October 19, 2023

My name is Diane Berge and my husband and I own property at 1061 FS Rd 4517 in the Granite Creek Neighborhood. I strongly disapprove of the Fowler Creek Guest Ranch proposal, CU-23-00003, for many reasons, but these Comments are in response to their response to KCC 17.60A.015, the Review Criteria for granting of Conditional Use.

EXHIBIT 16 - SITE PLAN - FOWLER CREEK GUEST RANCH

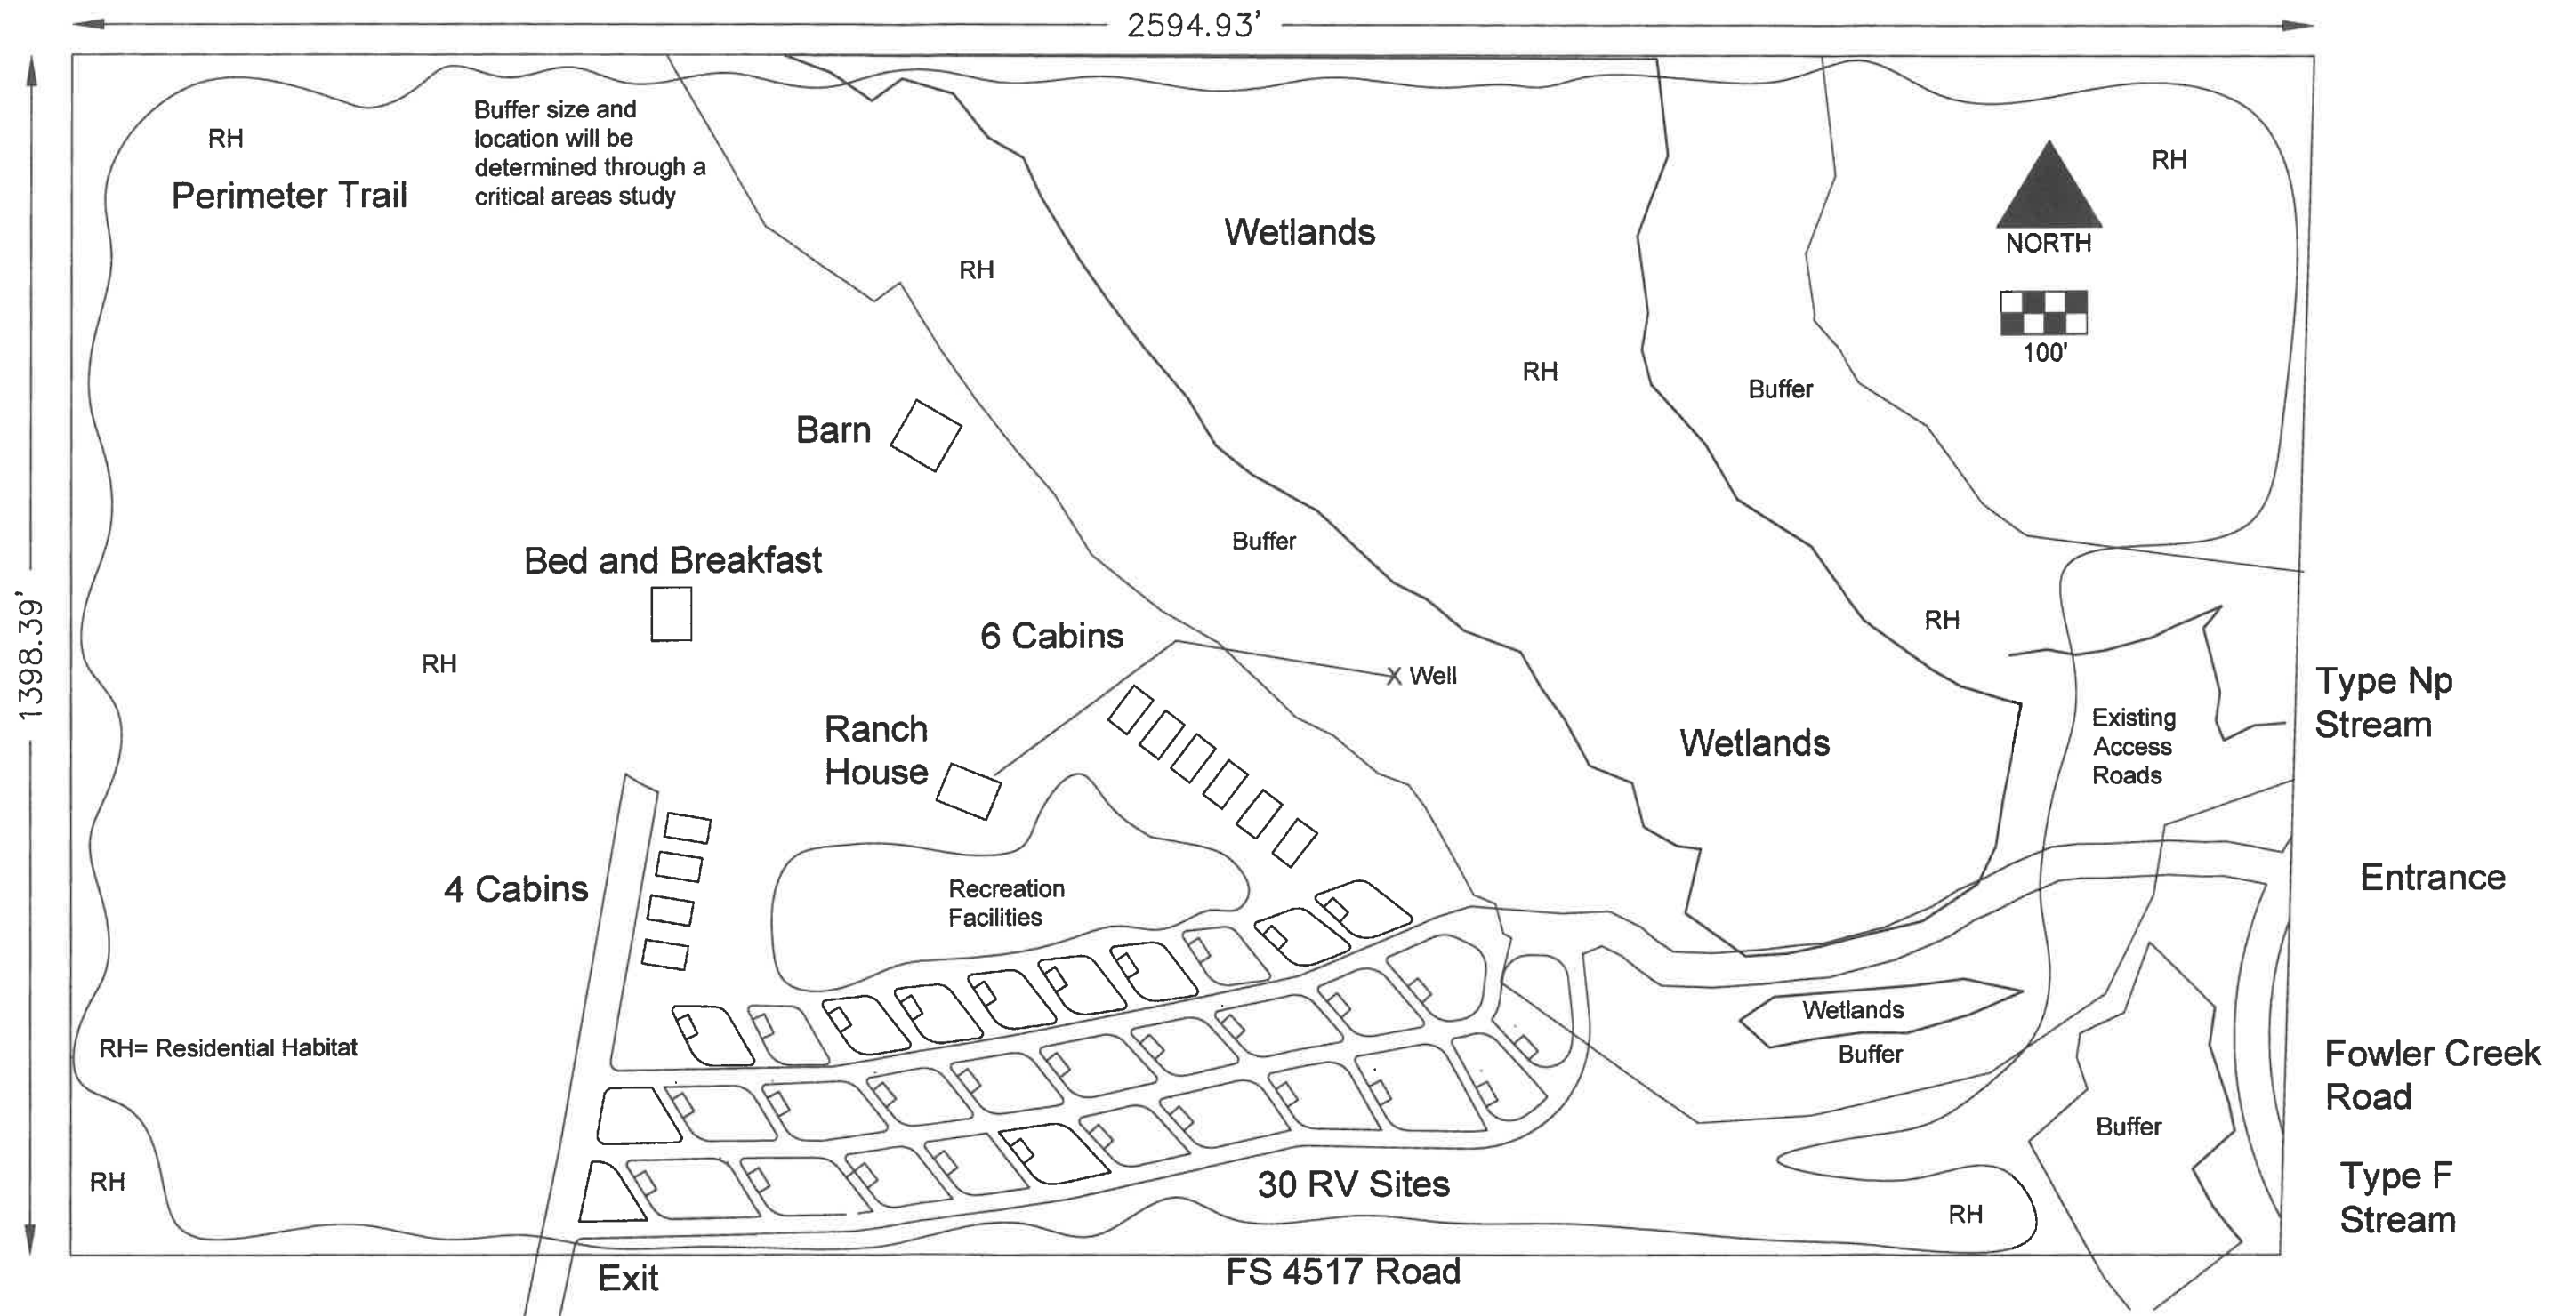
- c) The Site Plan shows buildings and RV sites in close proximity to nearby residents. The developer has an 84-acre parcel. They shouldn't put them so close to nearby residents. Can Landscaping & Screening even be provided given the fire risk? See my previously submitted comments on noise, and the included graphic that shows the egress from the development to FS RD 4517 runs though private property via easement, just feet from the person's home. There are other homes also in close proximity to this egress for both vehicles and recreational motorized vehicles. The developer likely tried to obscure this information. The site plan doesn't show this easement, and also doesn't show the dangerous section of FS Rd 4517 traffic would need to travel to exit the development.
